I wish to update my Relevant Representation submitted on 17 July

As a chartered geotechnical engineer experienced on highways/coastal engineering and related litigation I have examined the DCO documentation. I have concluded that for the matters I have examined, adequate and sound principles have not fully adopted. I cannot support the DCO proposals.

## HCDF

**DRAWING TITLE:**  
 NORTHERN PARK AND RIDE PROPOSED DRAINAGE PLAN

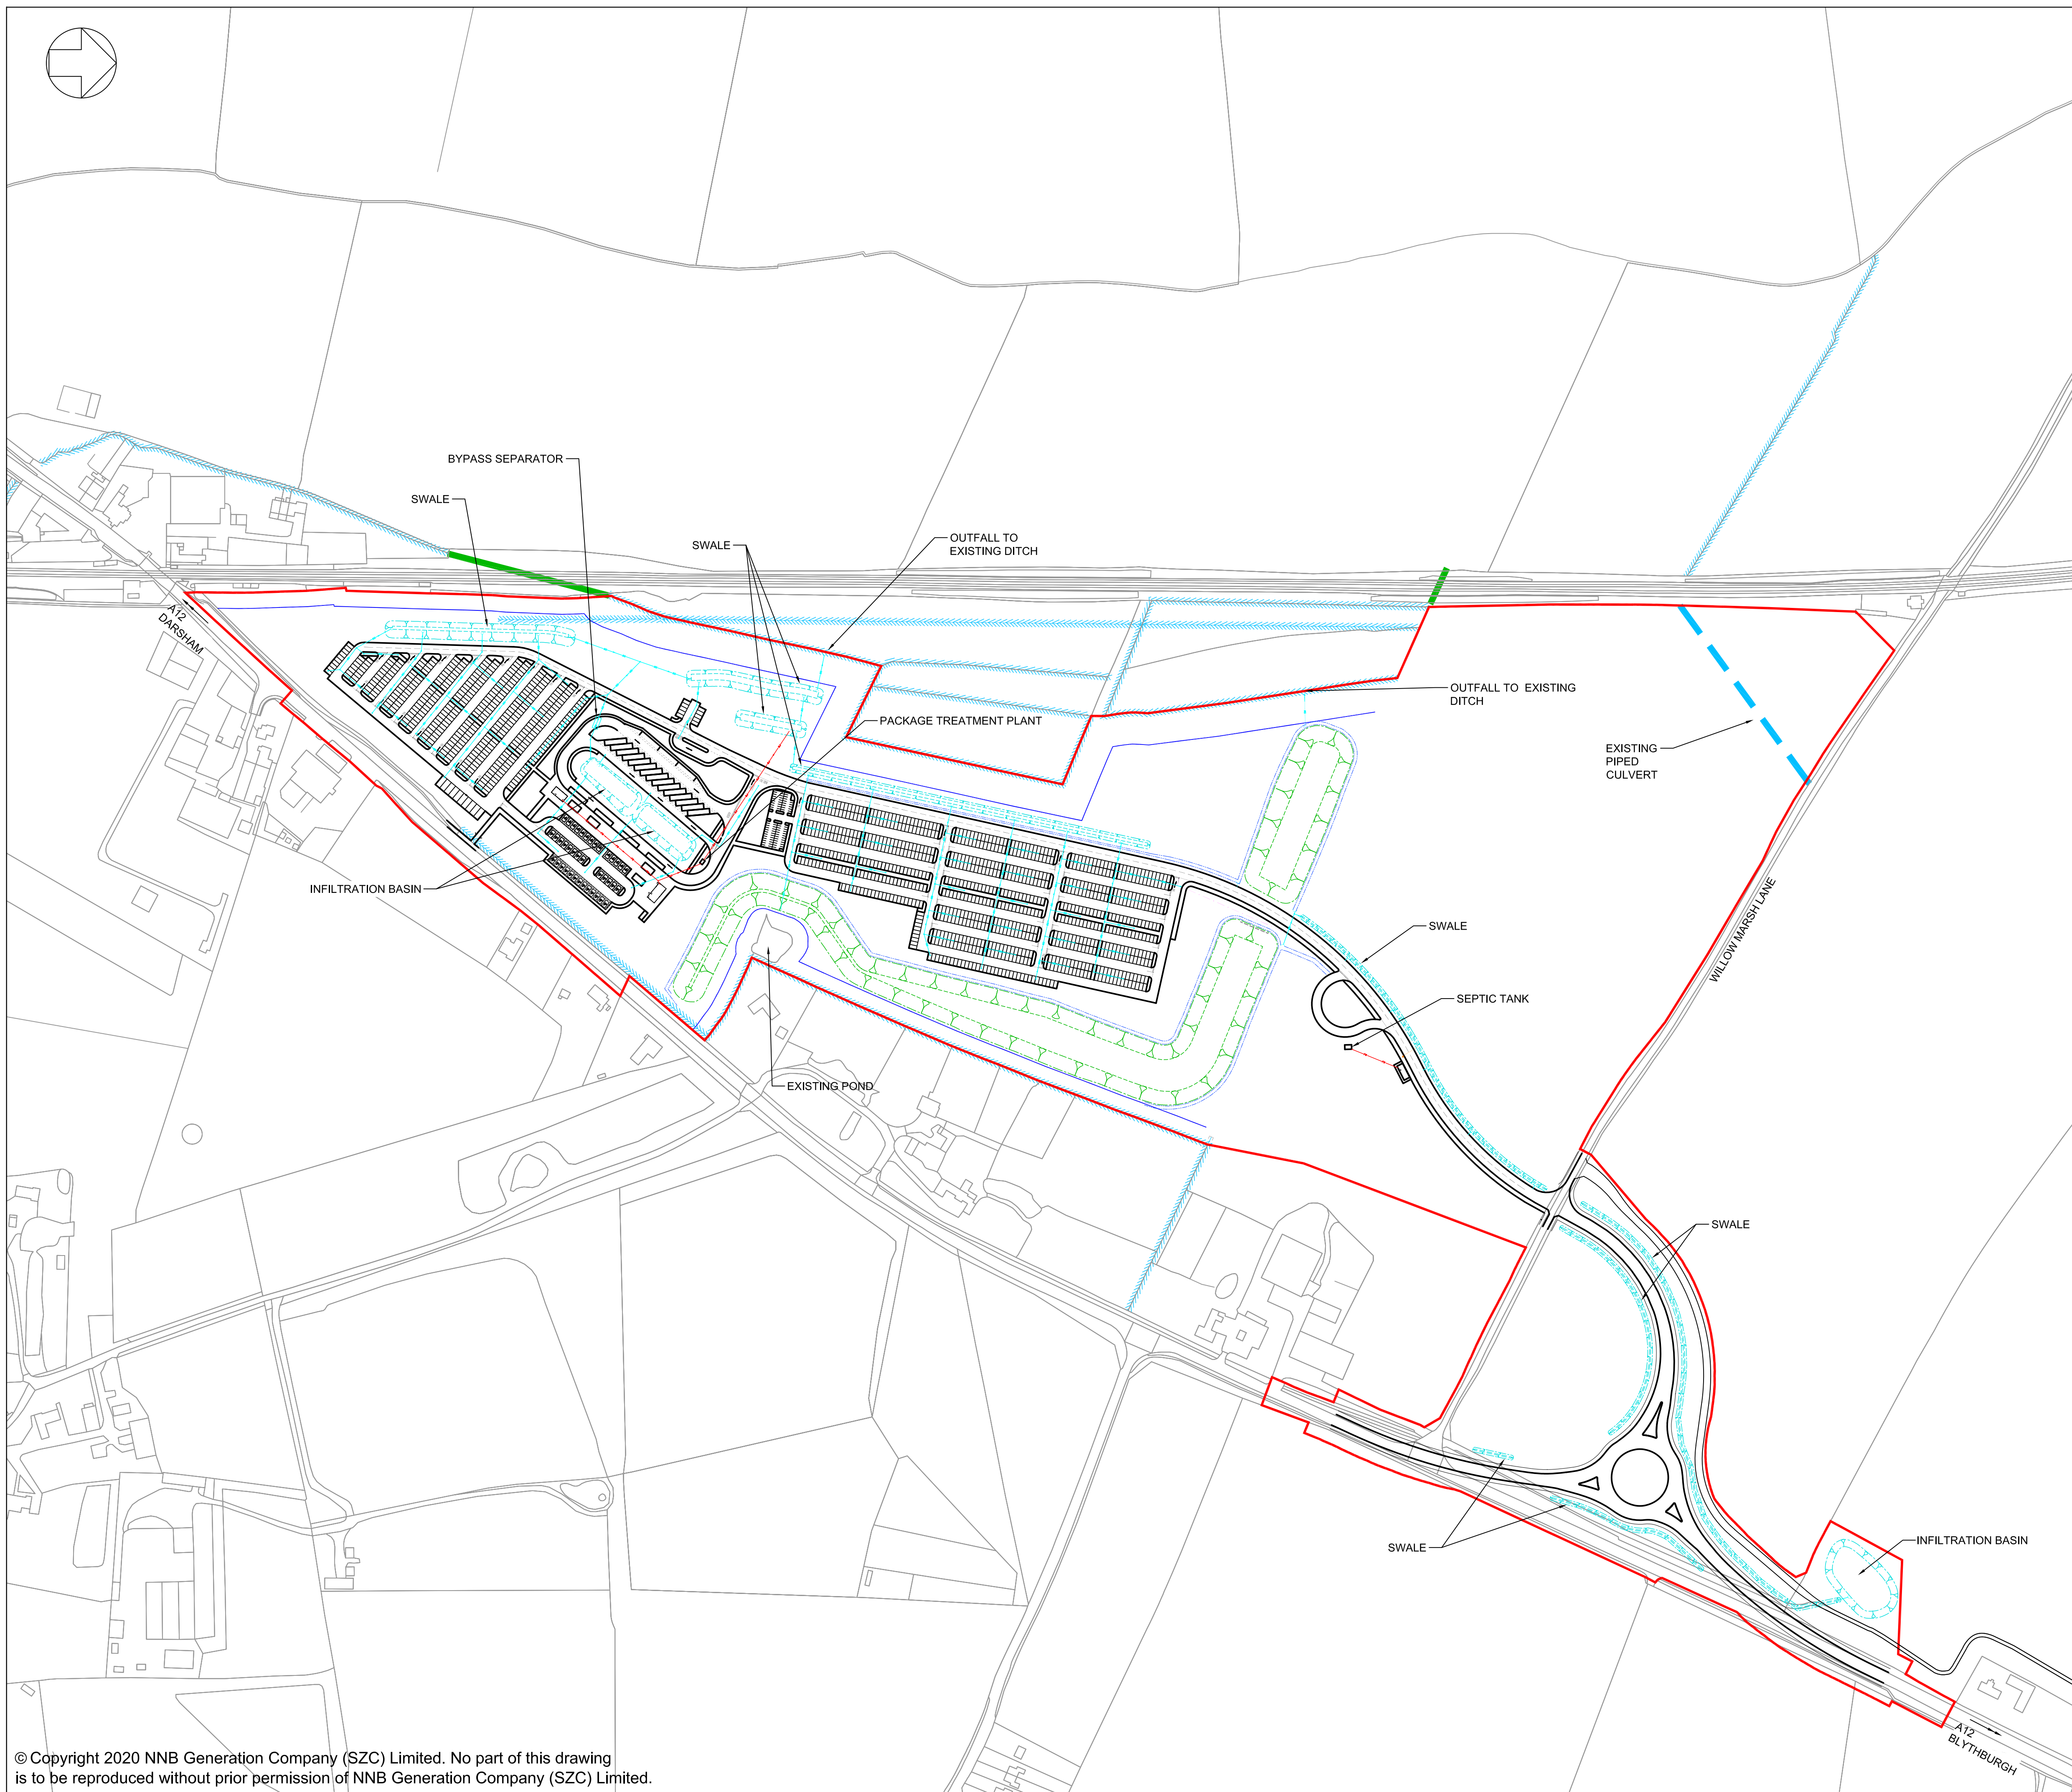
The drainage is proposed to be infiltration into underlying geology. The DCO geotechnical

reports state the site is underlain by Lowestoft Till. Those reports state it is 'boulder clay' or sand and gravel. The latter least likely. The FRA has assumed sand and gravel with no consideration of clay. This is a fundamental error invalidating the FRA findings and the drainage design.

DRAWING TITLE:
PERMANENT COASTAL DEFENCE FEATURE
TYPICAL SECTIONS (MAIN)

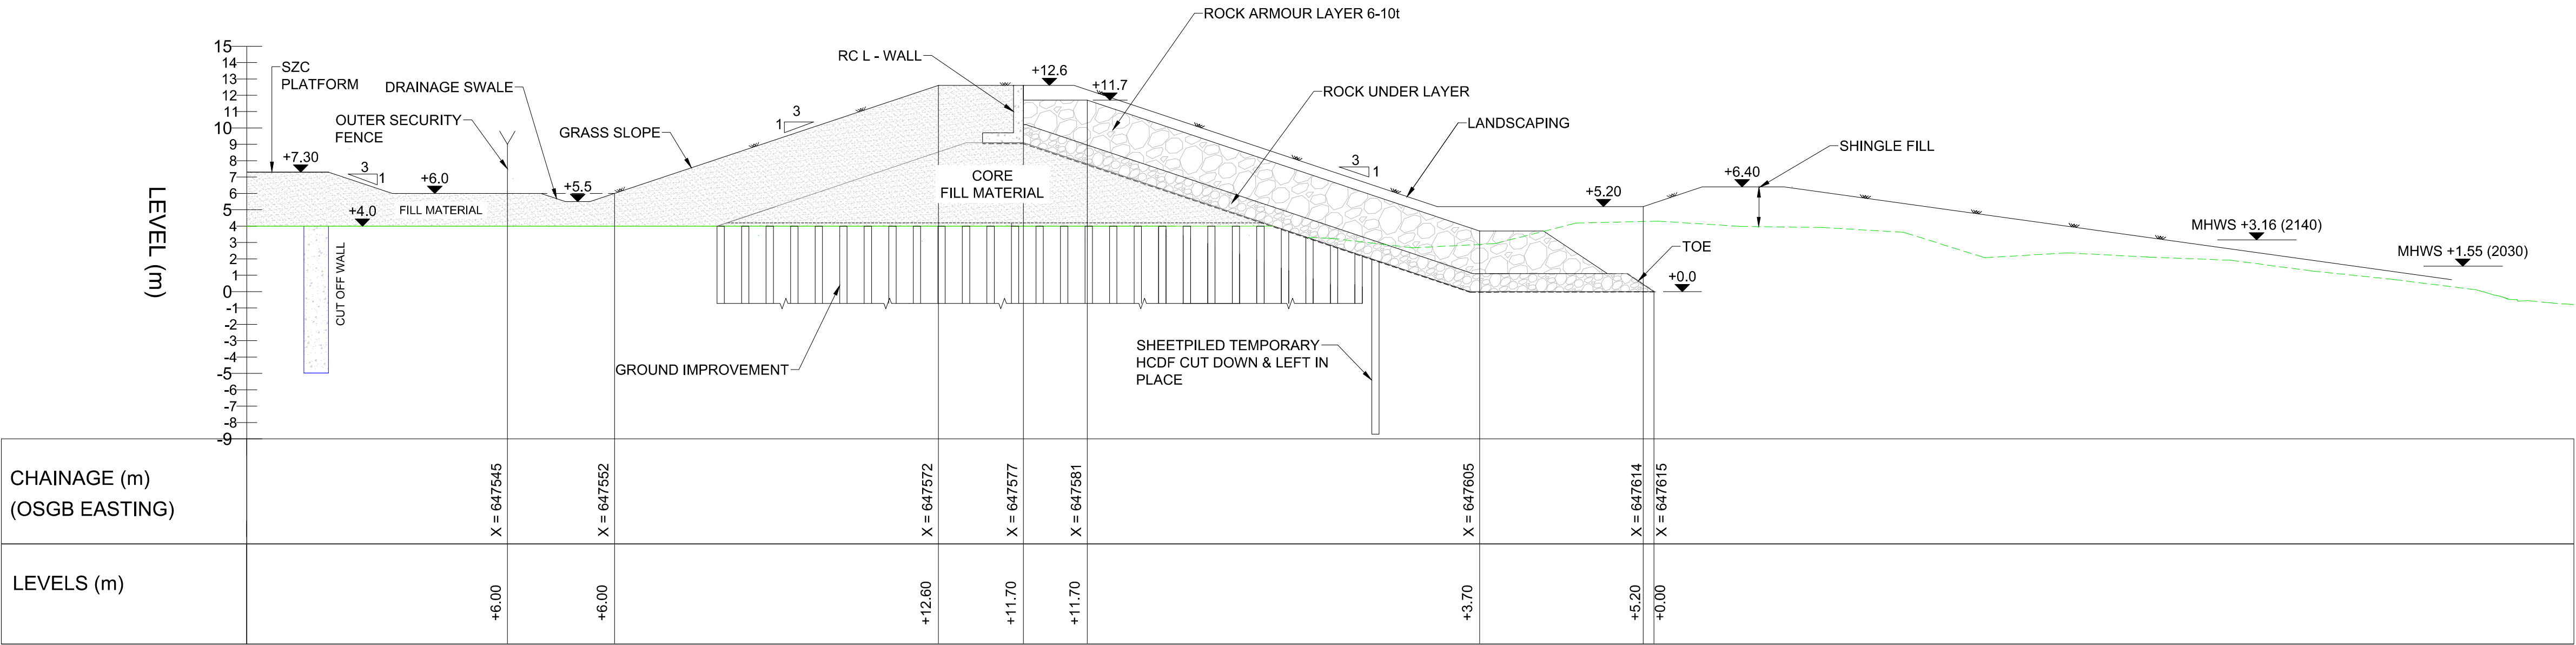
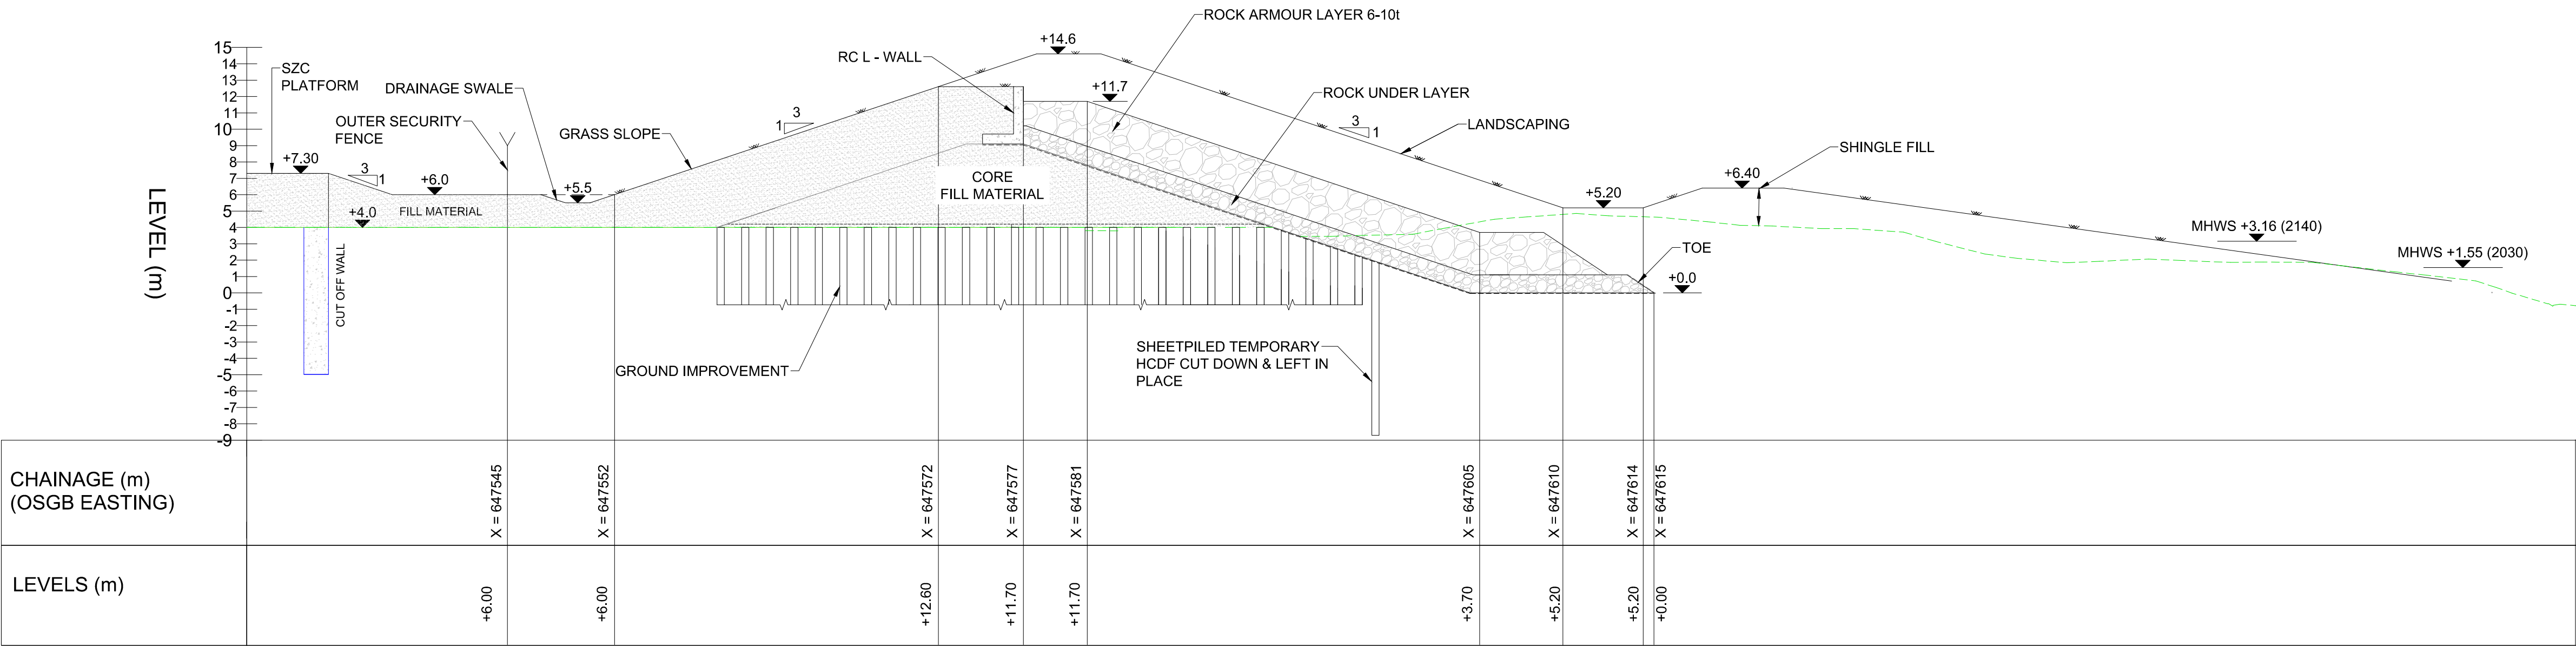
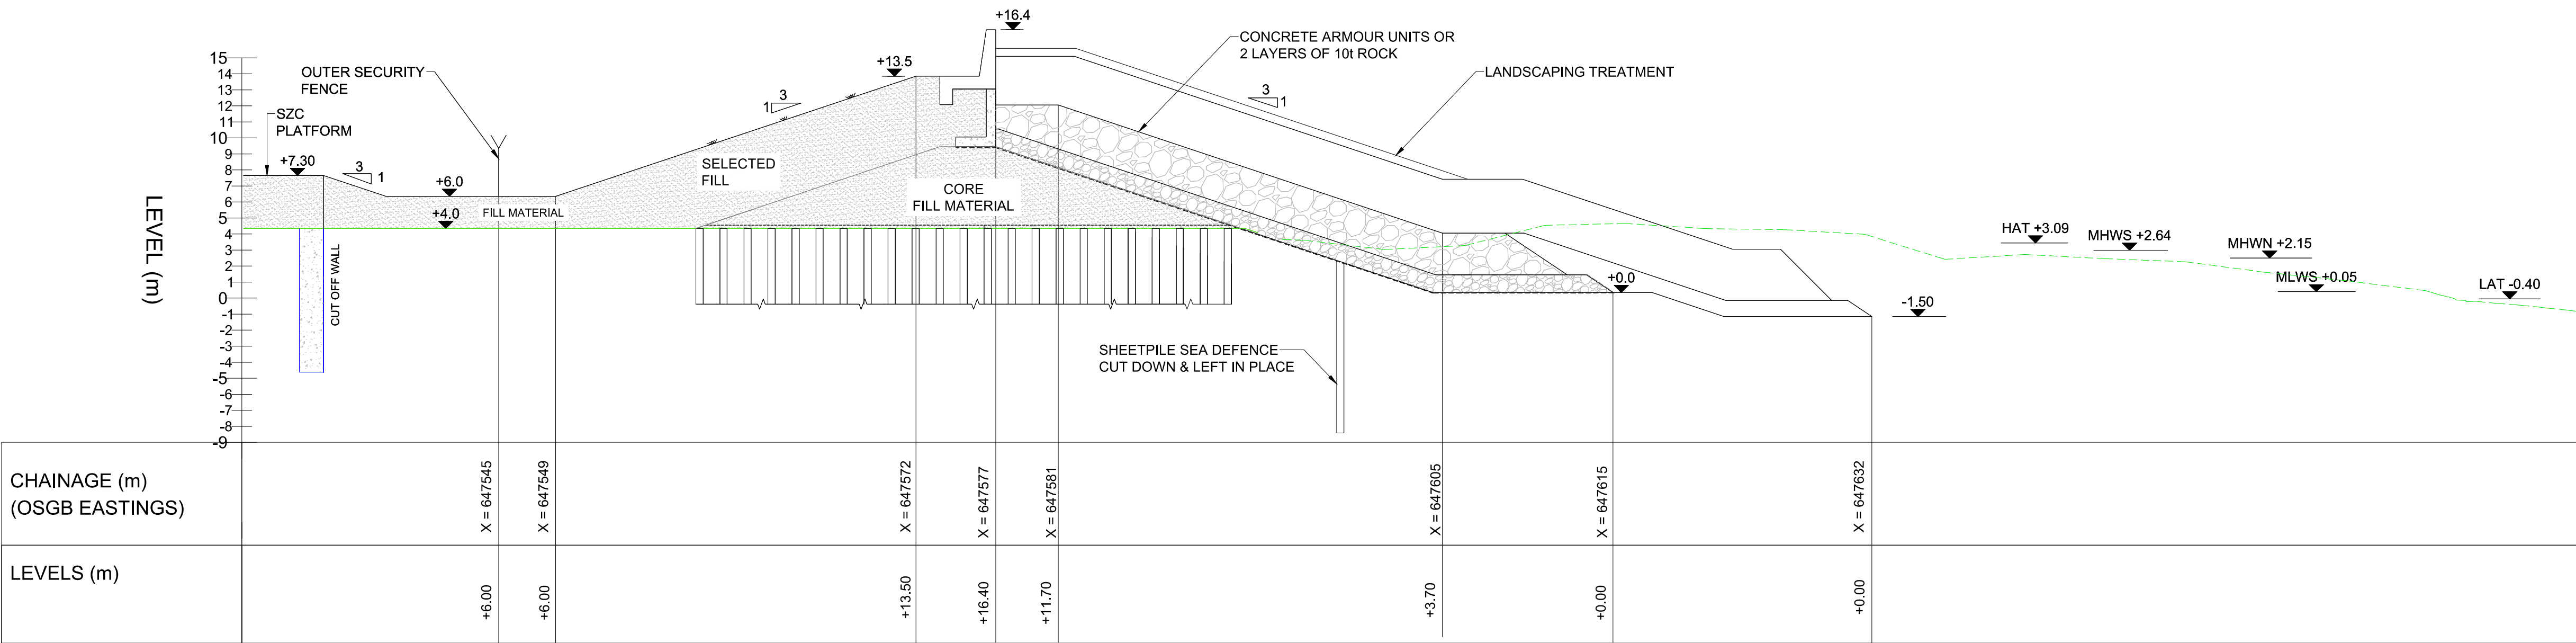
- The DCO analysis sections of the adaptive defence level of 14.2m do not appear to include rock armour above 10.2m - it will fail when wave heights exceed 10.2m. The DCO documentation indicates such events are expected to occur.

- The toe depth of the HCDF has been inadequately assessed in the DCO documentation – only the 2018 ‘Best from the East’ storm wave heights has been modelled to determine toe erosion and not future wave heights. In my view the HCDF toe is of inadequate depth, as with Jacobs 2017 design. ESC coastal forum [REDACTED] at Key issue #2 concurs. Adequate toe depth is crucial to avoid catastrophic failure.

- The DCO documentation shows a ‘soft’ cover to the HCDF rock armour. Whilst not detailed a very heavy duty non-biodegradable geotextile has to be laid on the rock or the soft cover will be lost into the armour. Significant adverse impacts of the inevitable loss of geotextile to sea when the soft cover is washed away, as predicted by the DCO documentation, has not been considered.
